Please ask for: Mrs D Johnson
Email: daun.johnson@arun.gov.uk
Telephone: 01903 737762
Our Ref: LU/380/21/PL
Your Ref:
Date: 1st December 2021

Application for Planning Permission

Development: Replacement of 1 No PVCu window with a timber window to the rear (East) elevation. This application may affect the setting of a listed building, affects the Littlehampton Sea Front Conservation Area & is in CIL Zone 4 (Zero Rated) as other development.
Location: Regency Court Nursing Home 18-20 South Terrace Littlehampton BN17 5NZ

Clients: Aster Court Nursing Home
18-20, South Terrace, Littlehampton, BN17 5NZ
Proposed Block Site Plan
Scale: 1:250 on A3
GBS Design Services Tel: 07918 638 510
20 November 2021 Geoff BROWN MCIAT AssocRICS

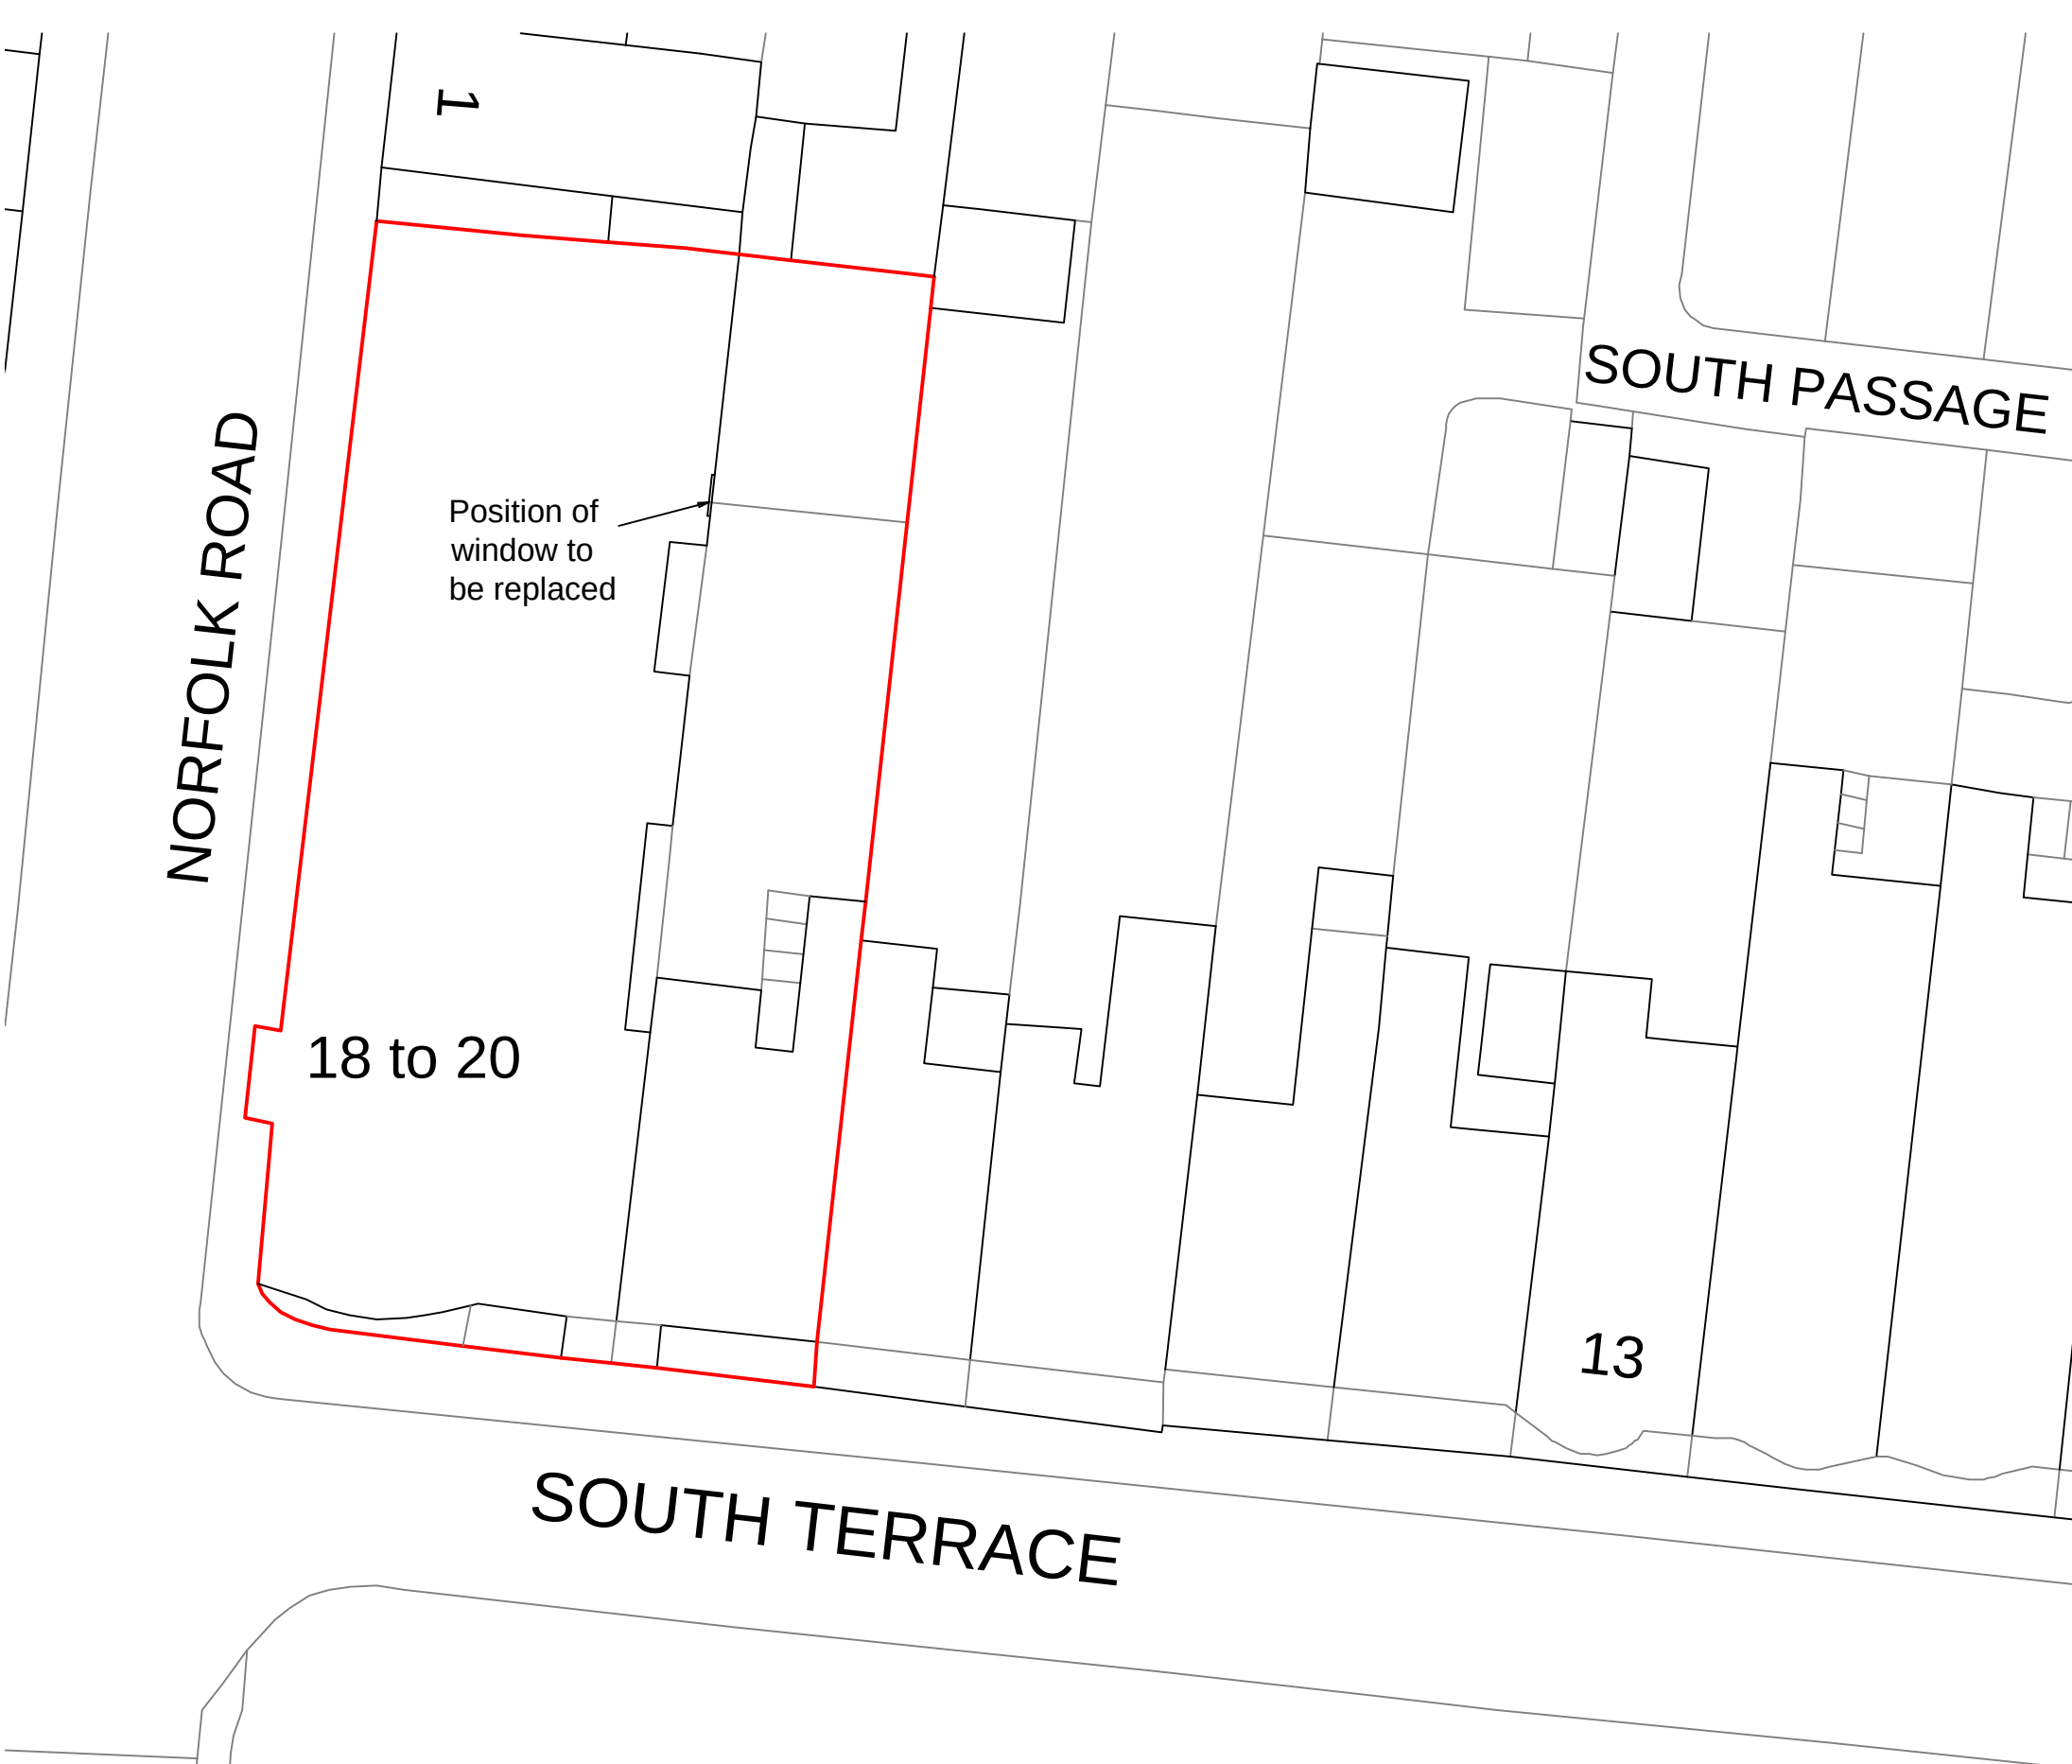
Block Plan

Please highlight the position of the replacement window.
